Project Title	Dapper's Lane, Angmering	Project No	20079
Client	Persimmon Homes Thames Valley		
Prepared By	S Marshall/C O'Brien	Date	23 rd March 2022
Subject	Civil Engineer Design Development Note (Rev A)

Item	Subject
1.	<u>Introduction</u> This Technical Note has been produced to detail the Civil Engineering design development following receipt and review of the RPS Letter Report dated 07th March 2022 and titled 'Geotechnical and Hydrogeological Review'. This can be used by Arun District Council to understand how the recommendations have informed the revised design and how the recommendations have been suitably achieved, which should close out all design matters and enable a discharge of condition number 18 and 19 in relation to planning ref: A/76/20/PL. The following key should be used for the below stated report recommendations and the respective actions / design decisions / responses: <i>RPS statement from Section 6.2 of their Letter Report: (italics)</i> Response (bold bullet points)

Drawing: 20079 - 211 C

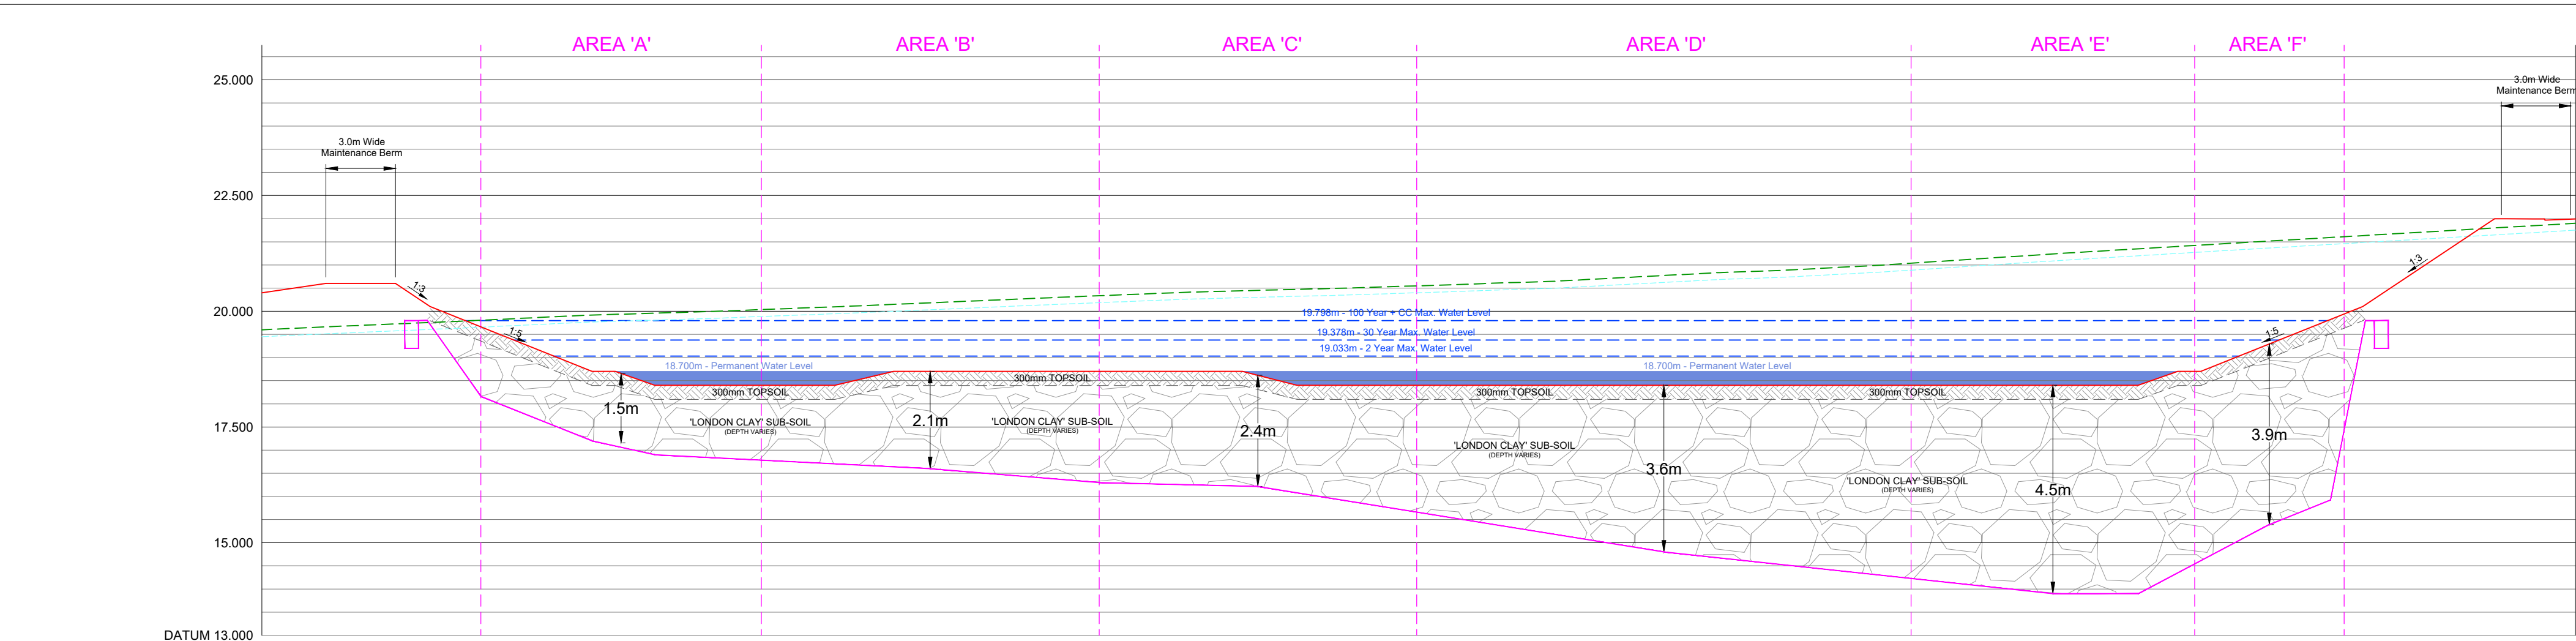
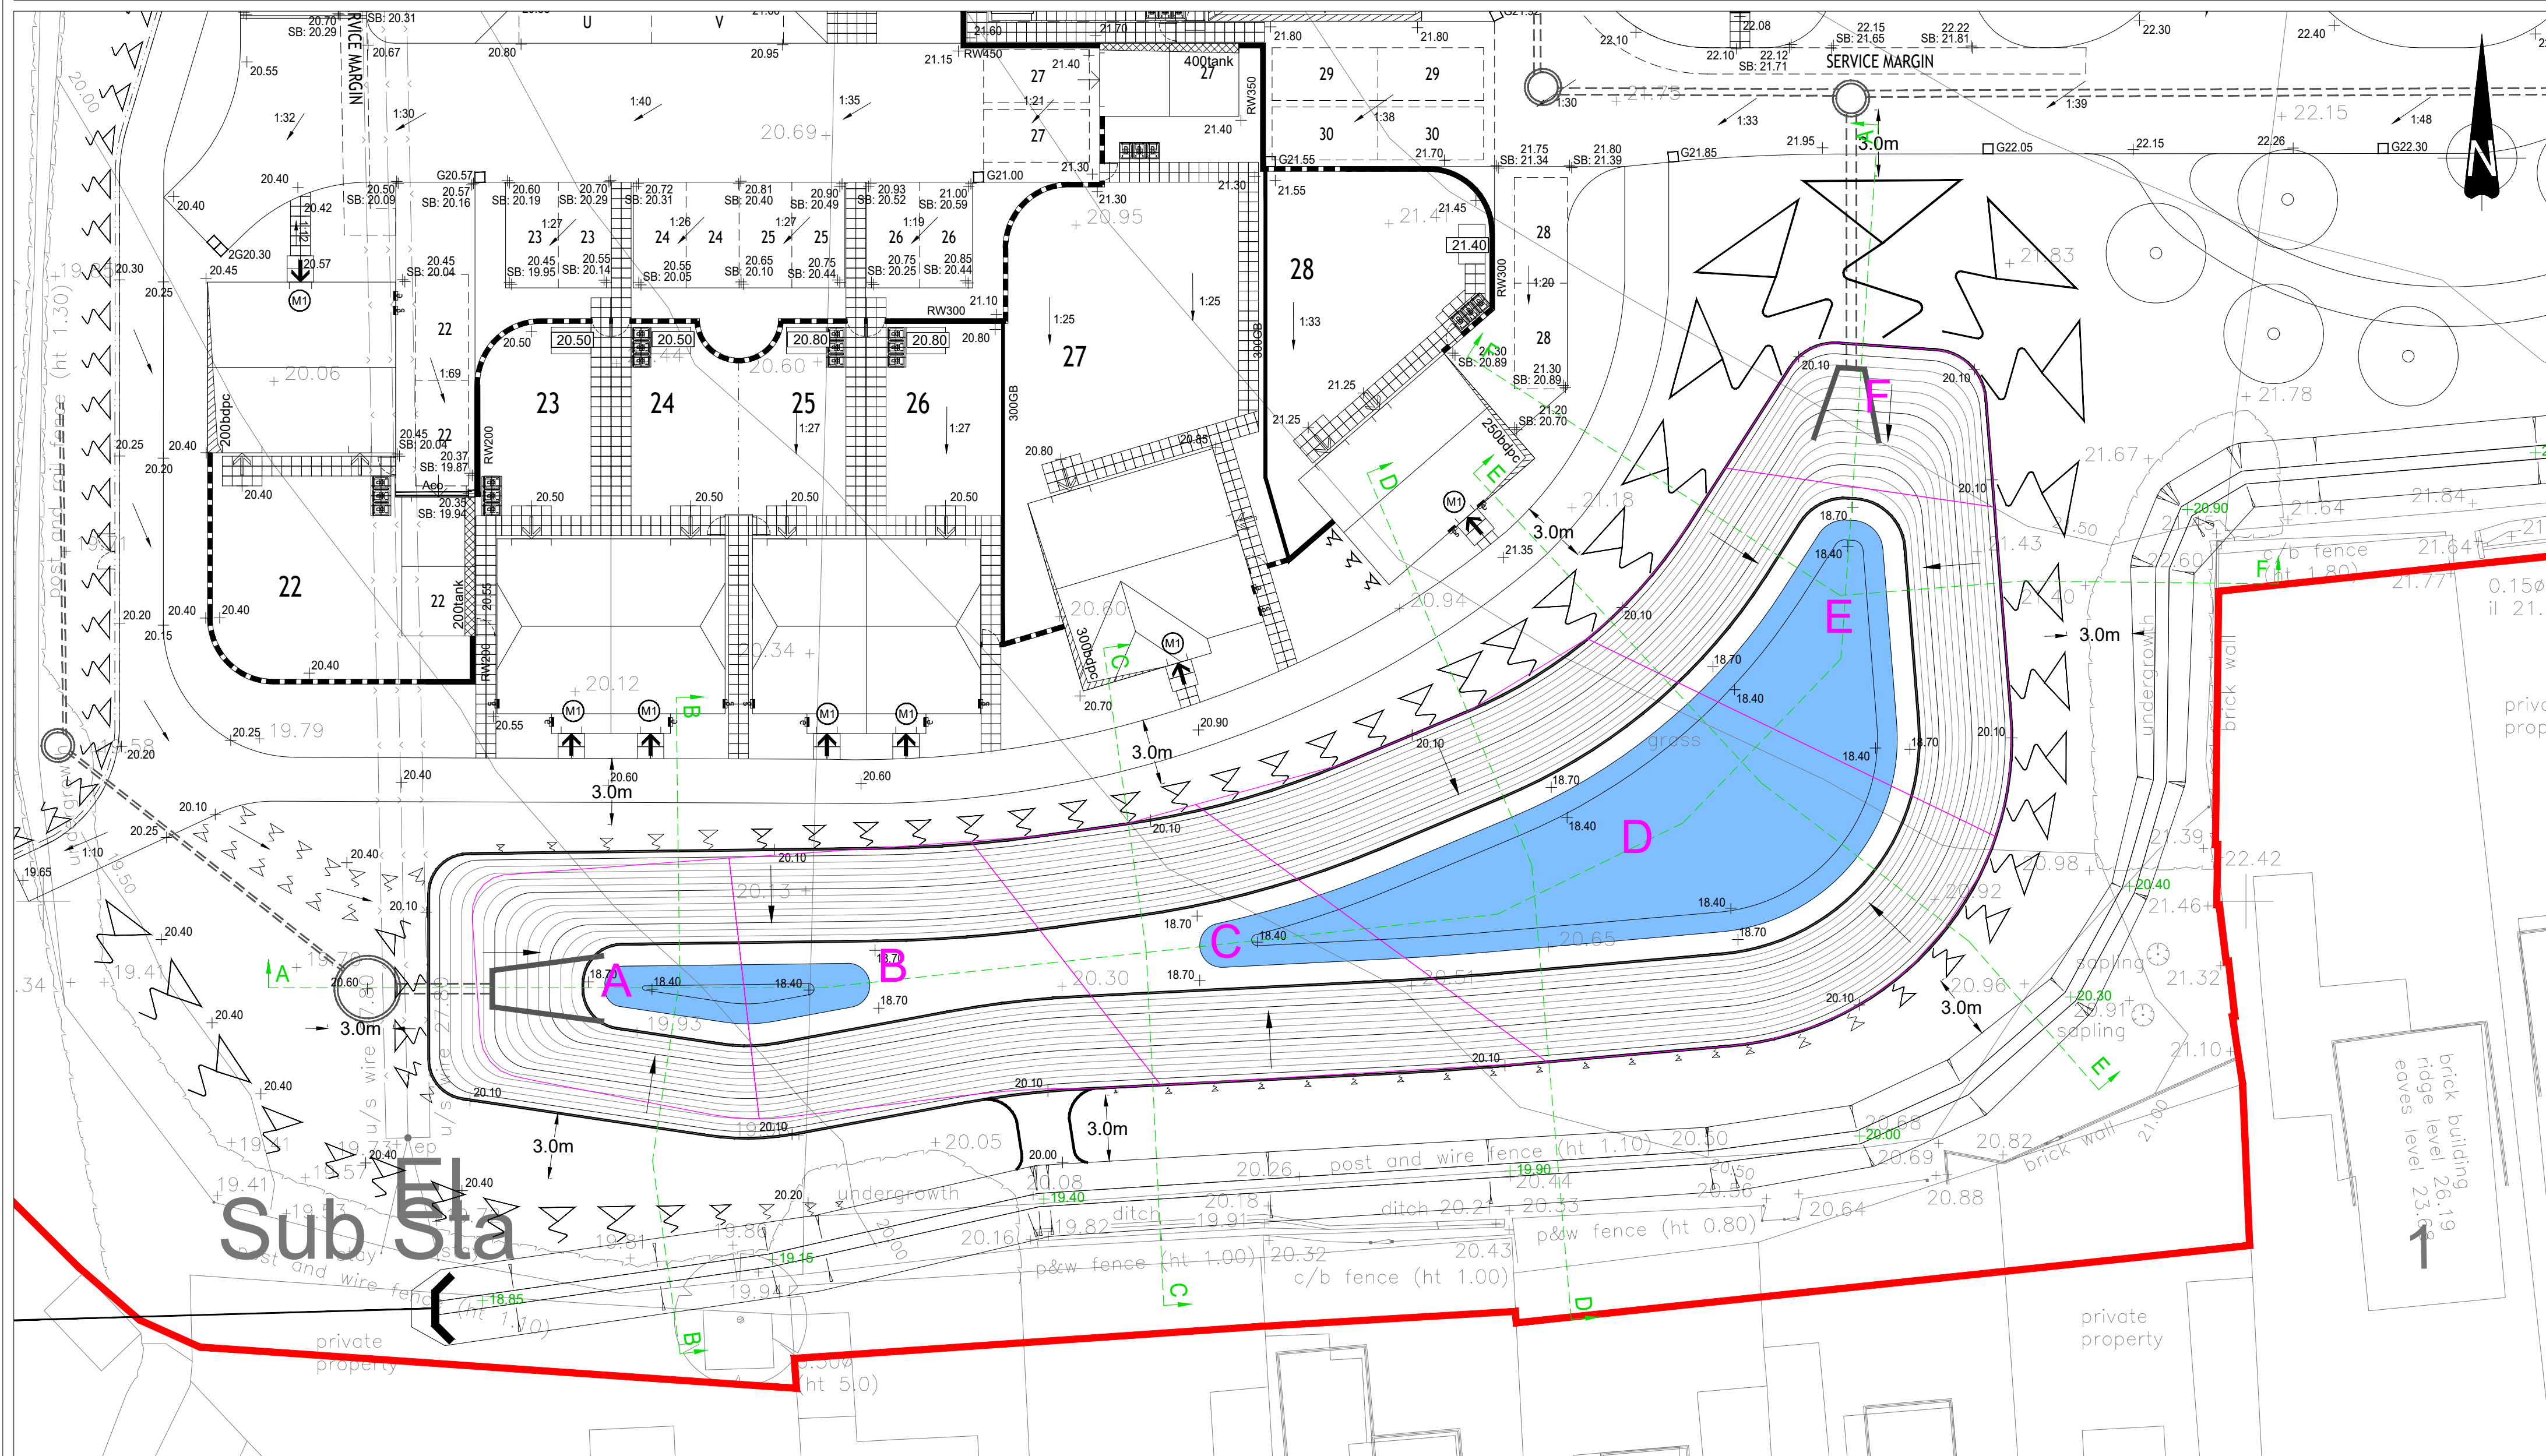
3.	<i>In the absence of confirmation data specifically on the effects of any hydraulic uplift from the London Clay, sufficient partial factors of safety should be applied to make allowance in the design of the potential variability. We would therefore recommend that loads should be factored in the Ultimate Limit State (ULS) design conditions using a partial factor of 1.1 for destabilising actions (e.g. porewater pressure), and 0.9 for stabilising permanent actions (e.g. water and soil weight), in accordance with an EC7 design approach.</i> The design solution elements discussed in the following sections mean that groundwater pressures under the intended location will be mitigated by a cut off wall and therefore no buoyancy design will be required as there will be no groundwater beneath the pond. Refer to Sections 4-7 of this Technical Note.

7.	<i>Reassessment of the surface water drainage strategy and calculations to confirm that the current pond has sufficient storage to account not only for attenuation of flows above the site surface water control discharge rate limits, but also to allow a contribution of calculated groundwater baseflow if the final solution needs to accommodate further contributions of inflow made from collection of groundwater from any associated control measures outside of the pond.</i>

Groundwater flows will not be introduced into the proposed surface water drainage system. Any groundwater flows will flow around the slurry wall and continue within the valley gravels.
